Further to our recent exchange of messages regarding the above application, I attach revised floor plans drawing 519/18-08 Rev A with the footprint of the original property superimposed over, similarly attached is the proposed elevation drawing 519/18-09 Rev A with the profile outline of original property laid over.

I refer to the above application. The Parish Council have objected for the following reasons:

FRONT ELEVATION

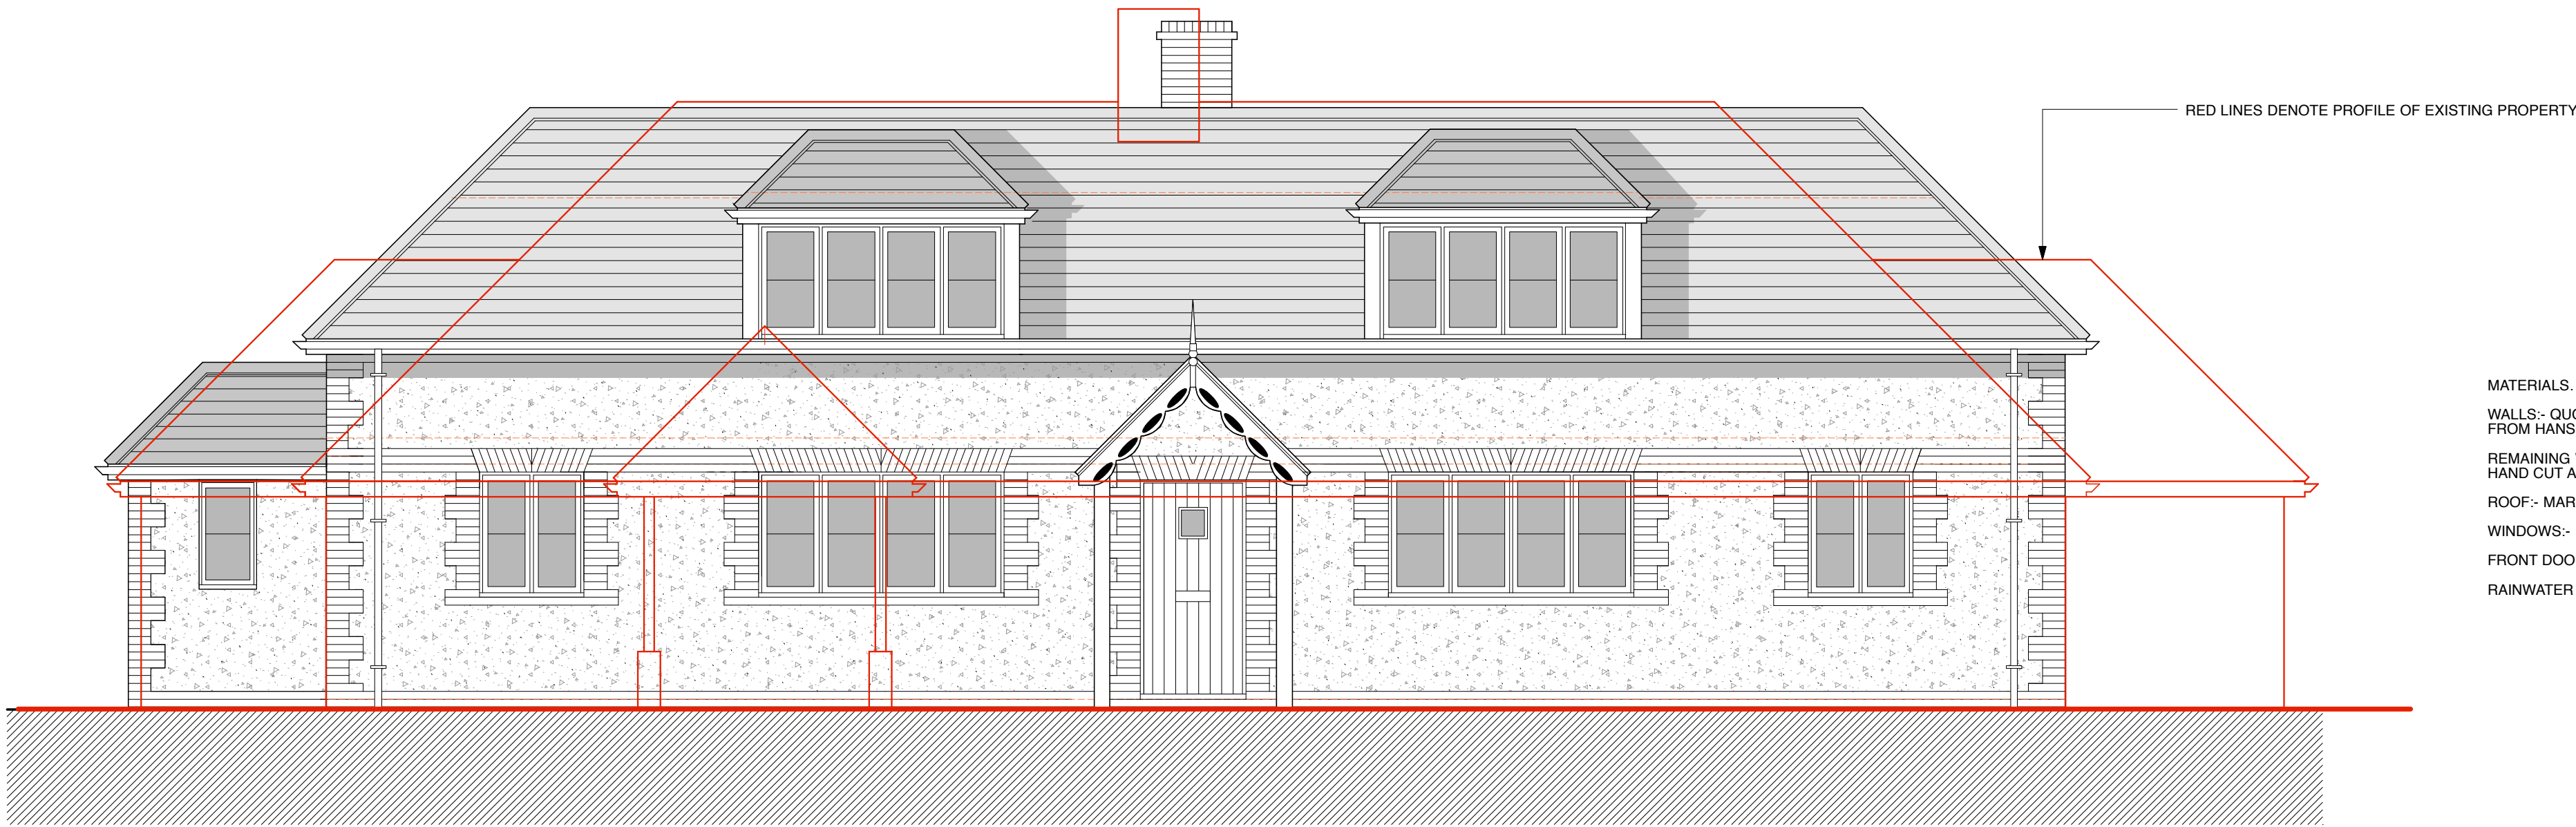
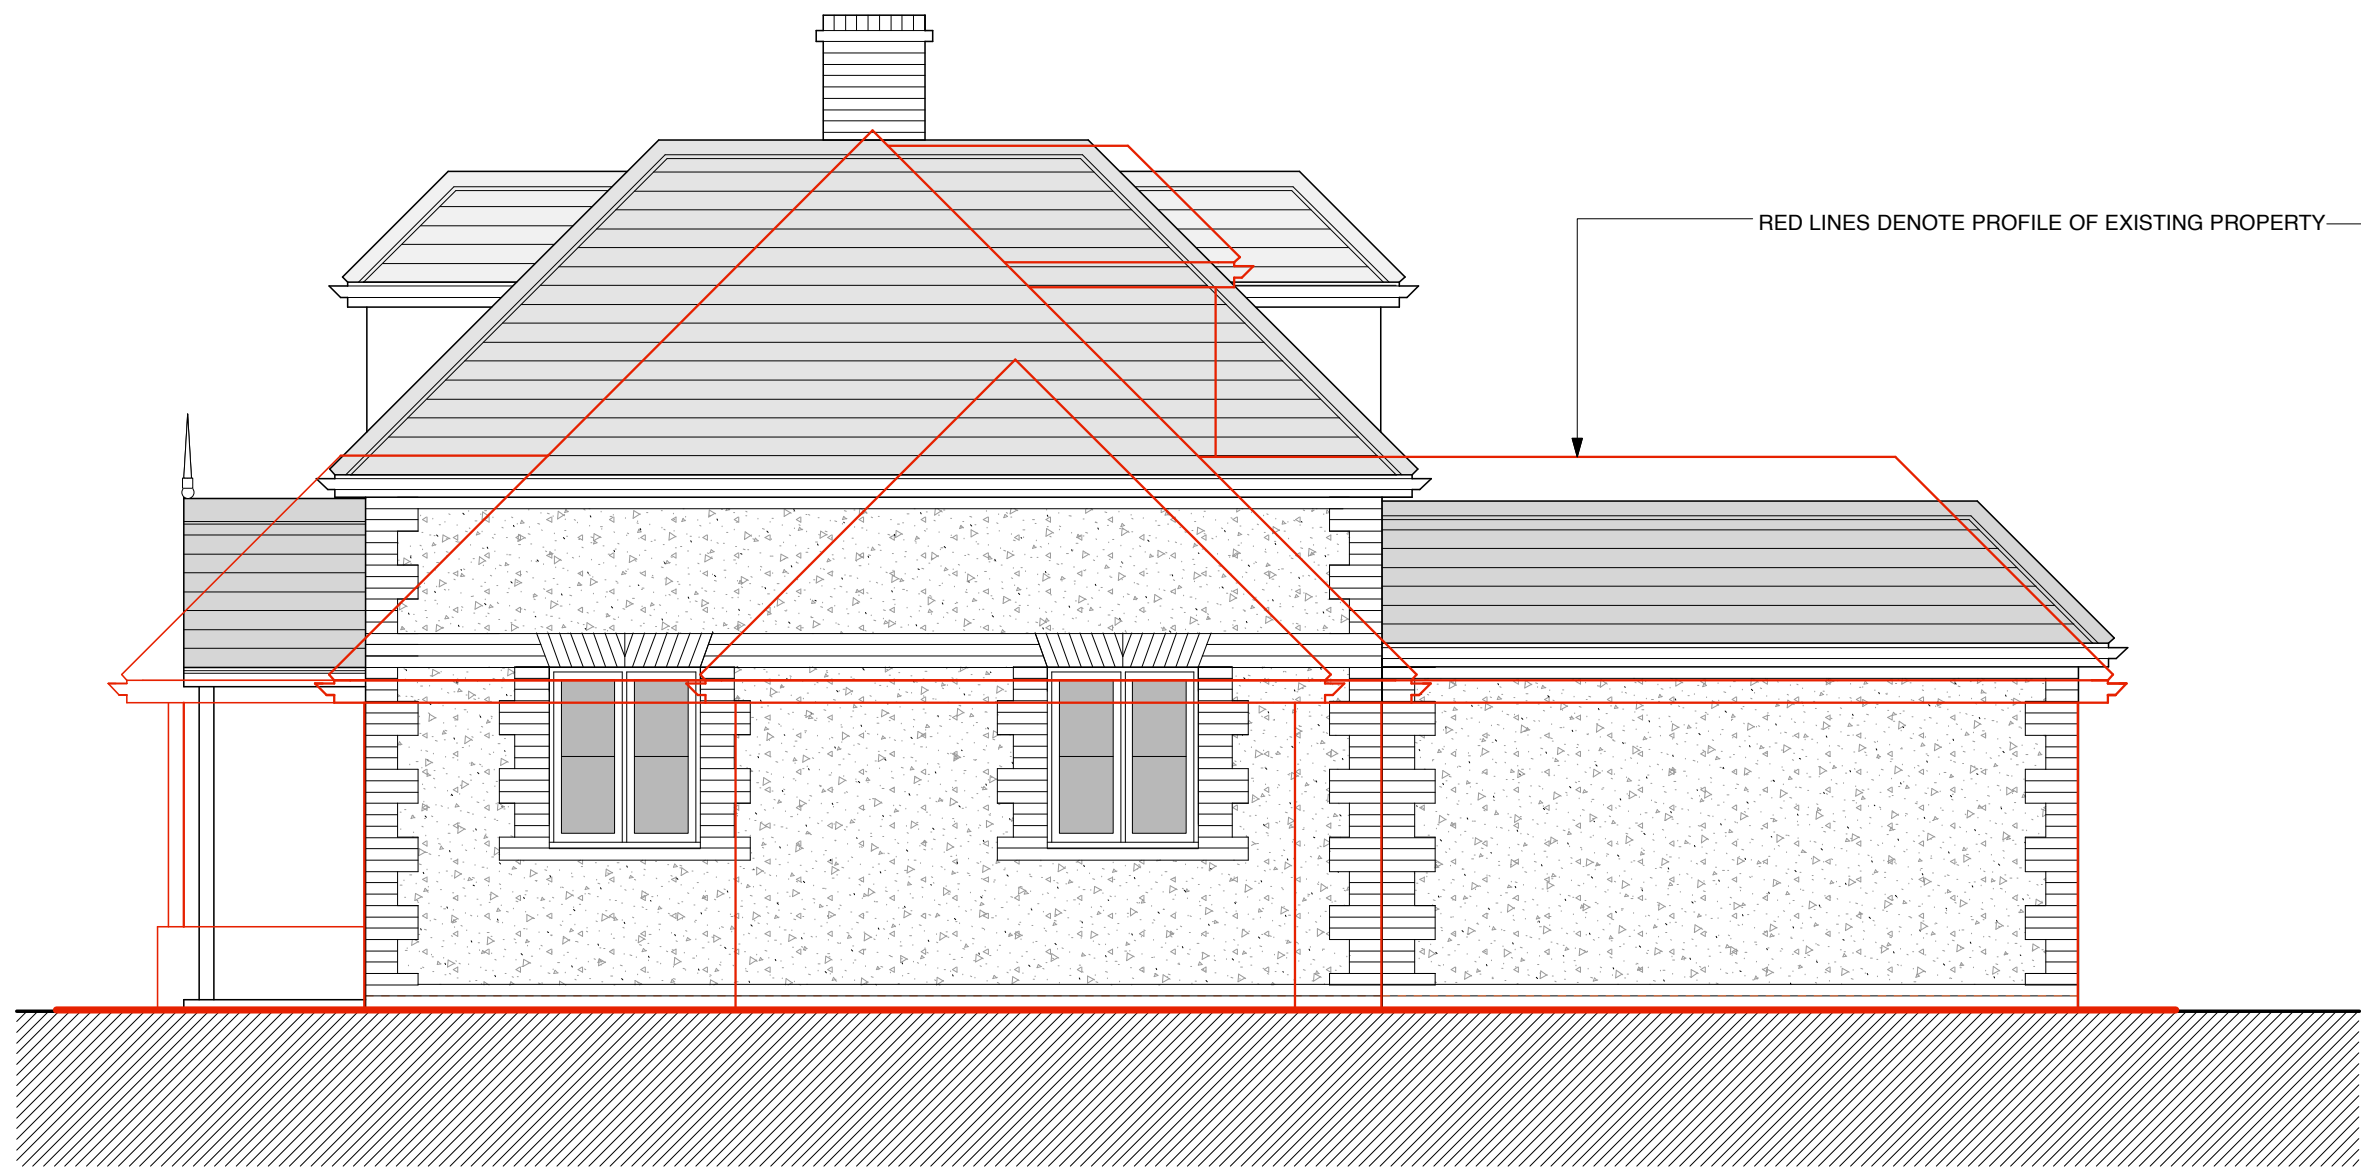
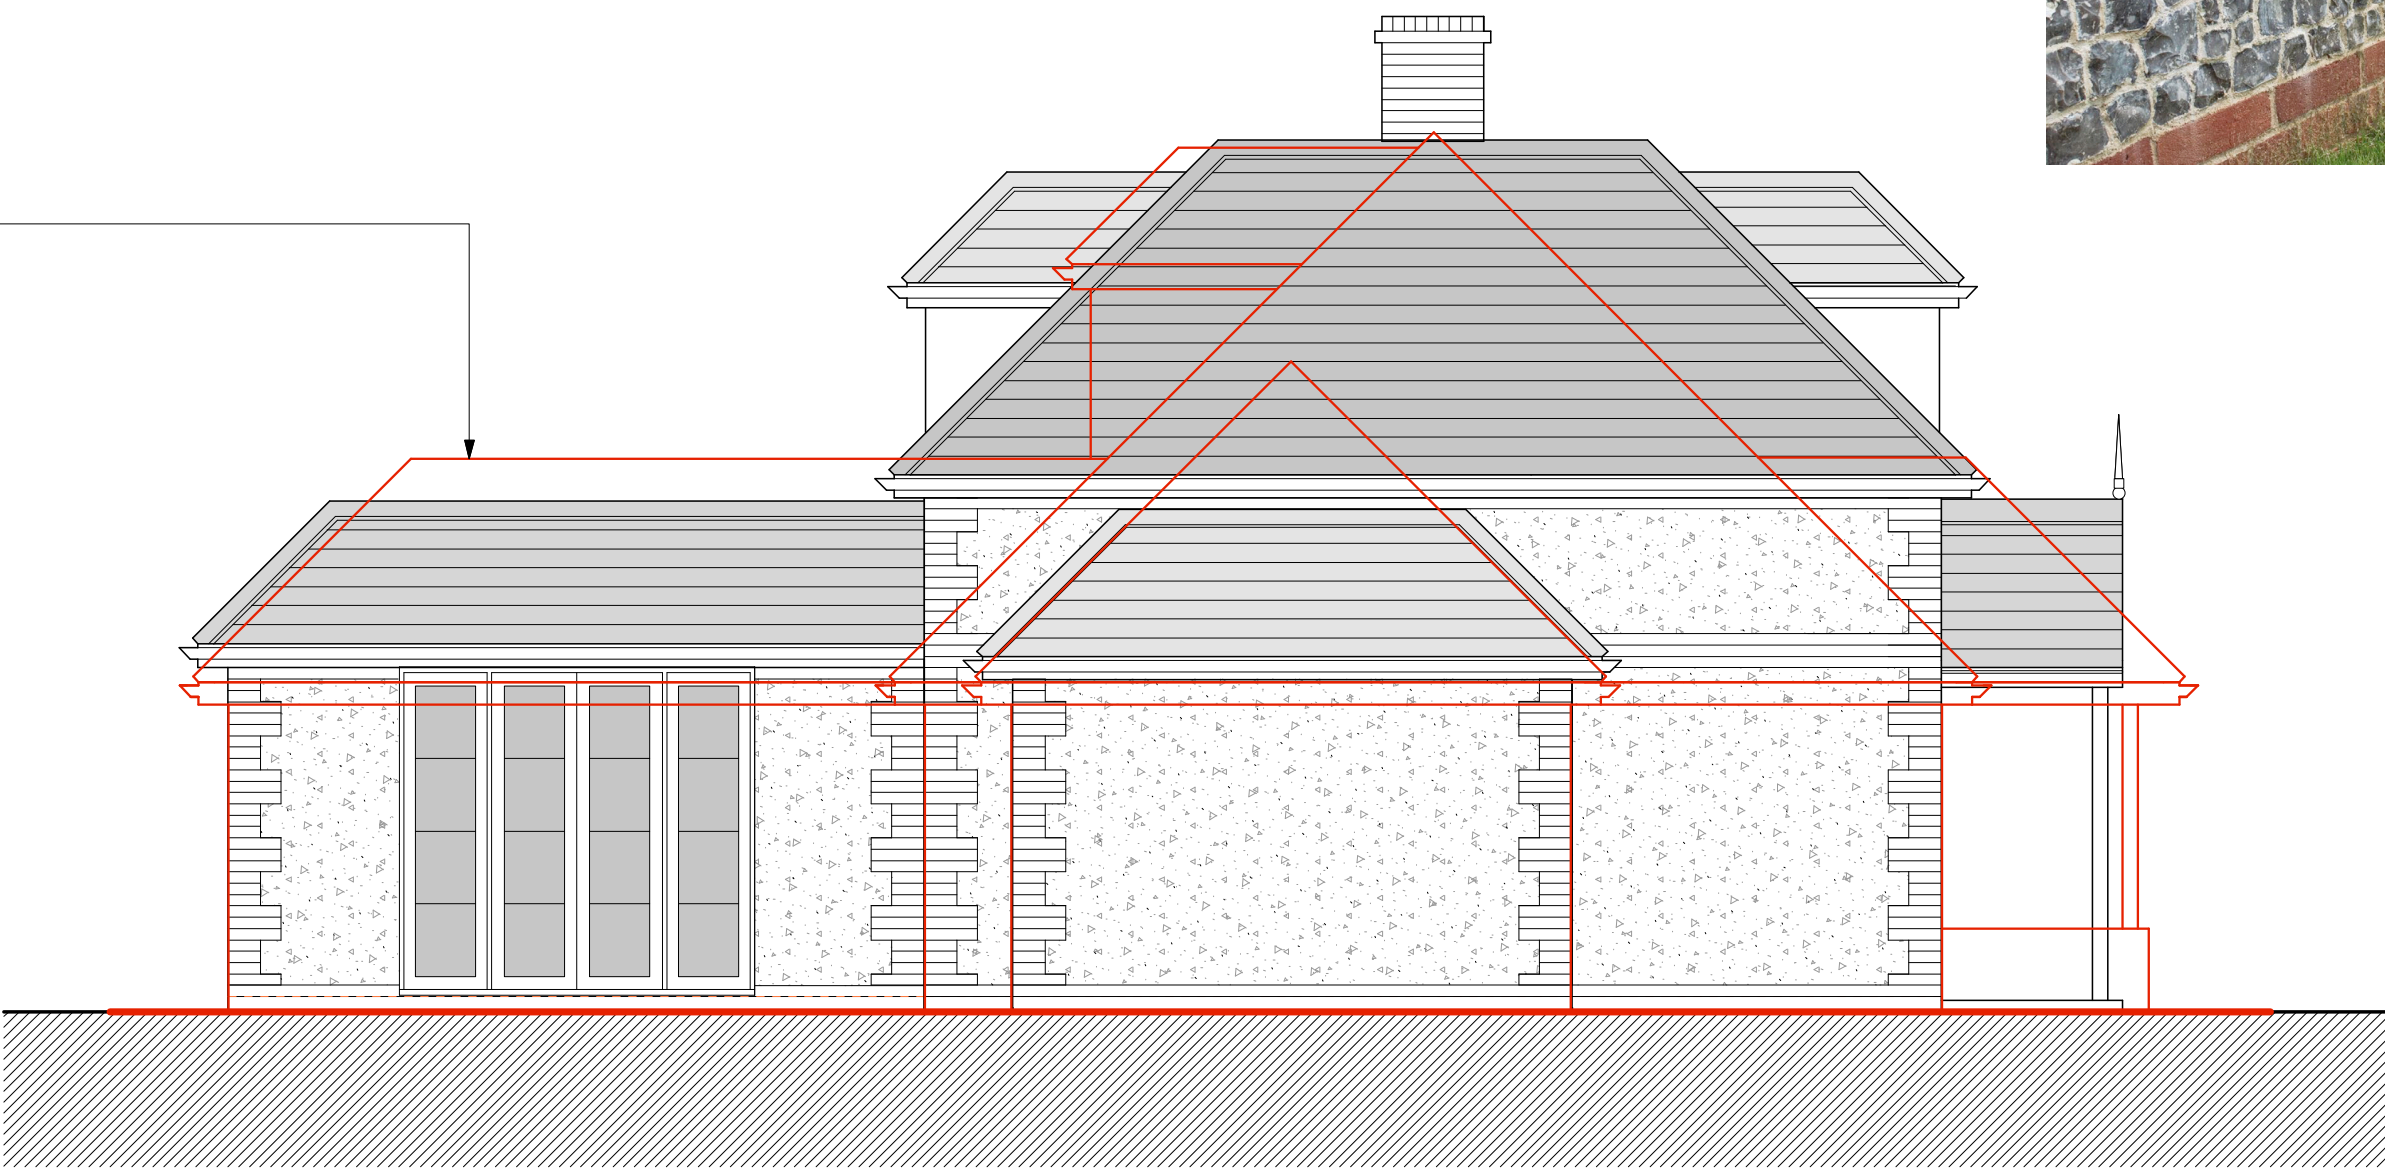
Further to our telephone conversation I have thought of another query. The materials are not referred to specifically on the submitted elevation plans and therefore won't be approved if the application drawings are approved. Since the dwelling is nearing completion it would be easier to the approve the materials with the plans rather than impose a condition. Accordingly can you arrange for the materials to be noted on the plans. I note that the tiles are as per the original dwelling, but have the elevation finishes altered? The form refers to 'natural finish' which should be clarified. You should provide details of the manufacturer of new materials together with the precise colour.

Previous concerns - Council repeats, for clarity, its previous concerns that the footprint and roof height of the new dwelling should match or are less than the demolished dwelling (roof height maximum 5.9 metres) and that materials to be used match those of the demolished dwelling.

Please can you provide comment and comparative footprint and elevations so that it is clear where any increase has occurred? I would appreciate receipt by the end of this week. As the application currently stands if it is recommended for approval the Parish Council objection will mean that the application will need to be determined by Development Control Committee and the March Committee agenda, which is the first available, closes at the end of this week.

Notes regarding the materials have been added to drawing 519/18-09 Rev A as referred to below.
